PLANNING CONSULTATION RESPONSE

Application No	<u>2026/0354</u>
Proposal	Erection of a residential care home consisting of 6 single bedroom self-contained units and a detached 2 bedroom respite bungalow for young adults (Use Class C2) with associated works including formation of accesses; car parking and landscaping.
Address	Land West of Cross Street, Worsbrough Dale, Barnsley,
Date of Consultation Reply	08/07/26
Consultee	Highways Development Control

Site Plan 1:200

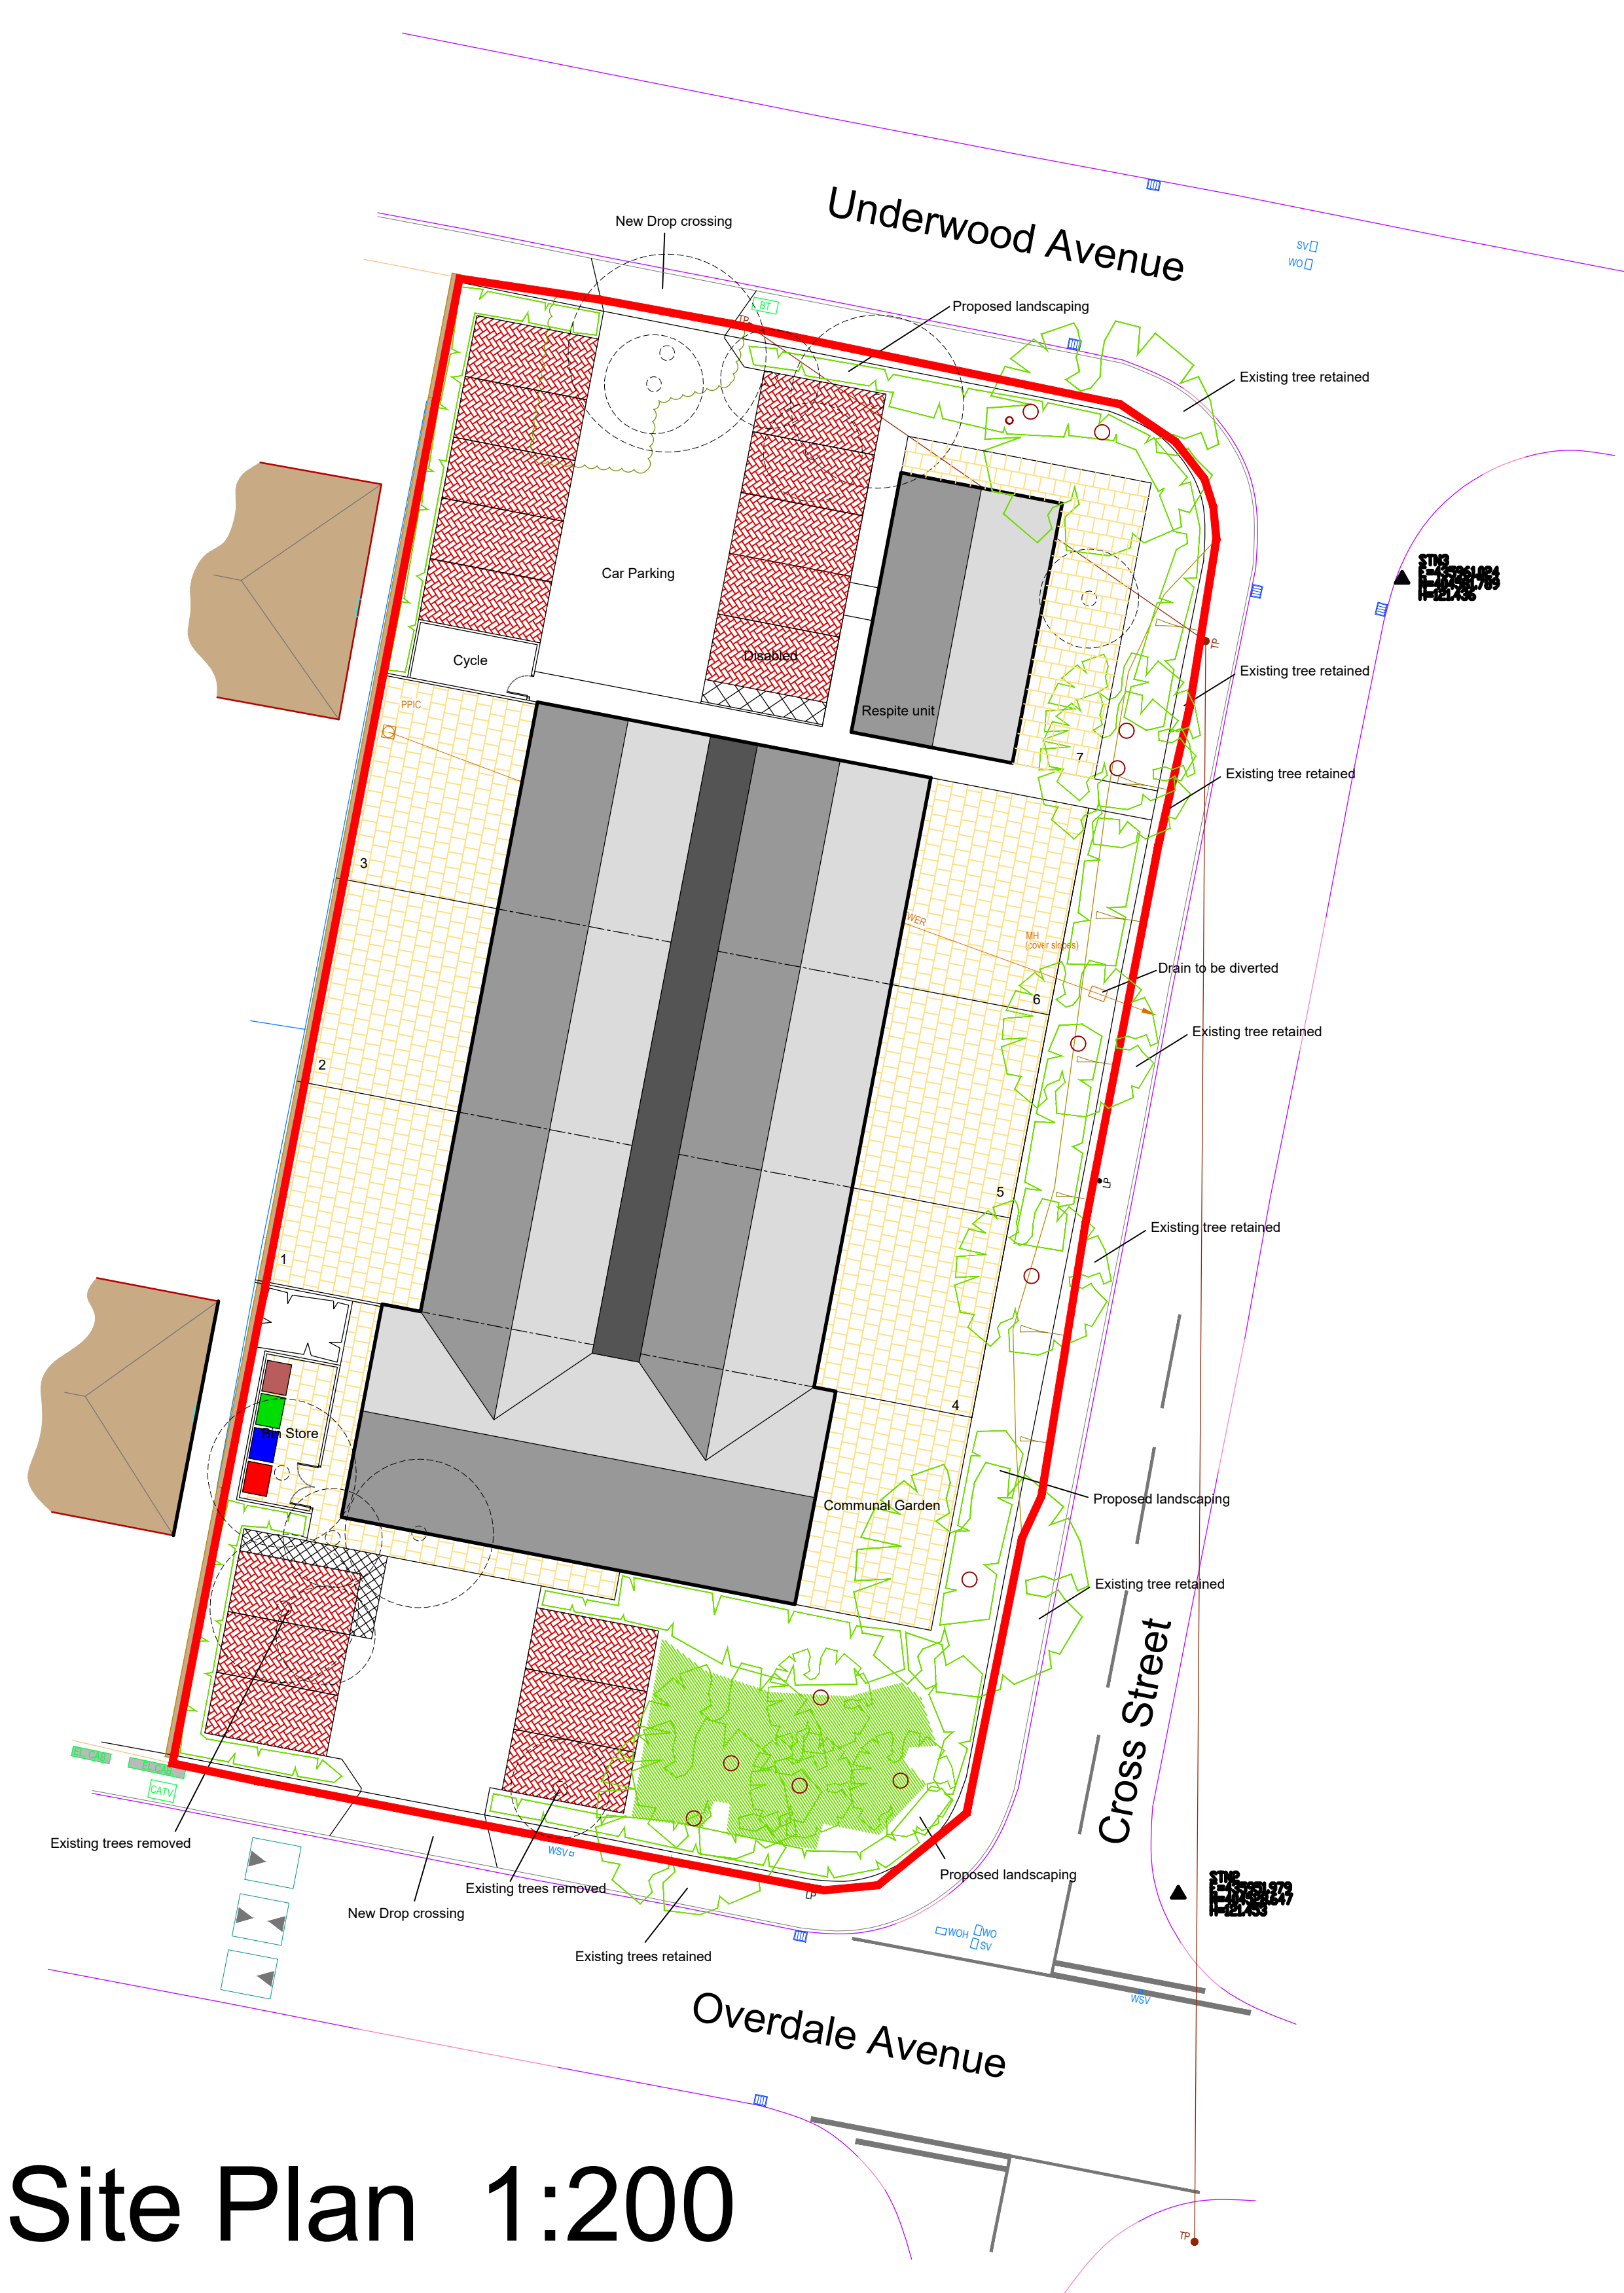
The application form states that 11 car parking spaces and 5 cycle spaces are proposed, however, insufficient operational information has been provided to demonstrate whether this level of parking is acceptable. Barnsley's Parking SPD requires C2 Residential Institutions to provide 1 space per 2 staff and 1 space per 3 daily visitors. In this case, the application form does not give details of the number of employees and, given the nature and scale of the proposed C2 care facility, together with the submitted floor plans showing office, staff canteen, staff bedroom, medical store and communal care related accommodation, this does not appear to provide a realistic picture on which to assess parking demand.

I also remain concerned that no clear servicing strategy has been provided. The proposal is likely to require regular refuse collection, deliveries, potential medical/waste collection and other service vehicle movements. The submitted layout does not appear to demonstrate suitable on-site turning for larger vehicles, and it is therefore unclear whether servicing would take place from the roadside. Such an arrangement could give rise to obstruction or disruption on Cross Street and Underwood Avenue, particularly where vehicles stop close to junctions, private accesses or areas of existing on-street parking.

The application also proposes new or altered vehicular and pedestrian access to the public highway. I would therefore expect the applicant to demonstrate that the proposed accesses are suitable in terms of visibility and vehicle manoeuvring. Swept path analysis should also be provided for the largest vehicle expected to access or service the site, together with confirmation that vehicles can enter and leave the site safely.

On this basis, I am unable to support the application in its current form and would recommend that further information is requested before the application is determined. This should include a detailed operational statement confirming staffing levels, shift patterns, visitor numbers and visiting professionals, a parking assessment based on Barnsley's adopted parking standard, a servicing and refuse strategy, swept path analysis for the largest vehicle expected to access the site and confirmation that the proposed accesses achieve appropriate visibility and safe vehicle manoeuvring.
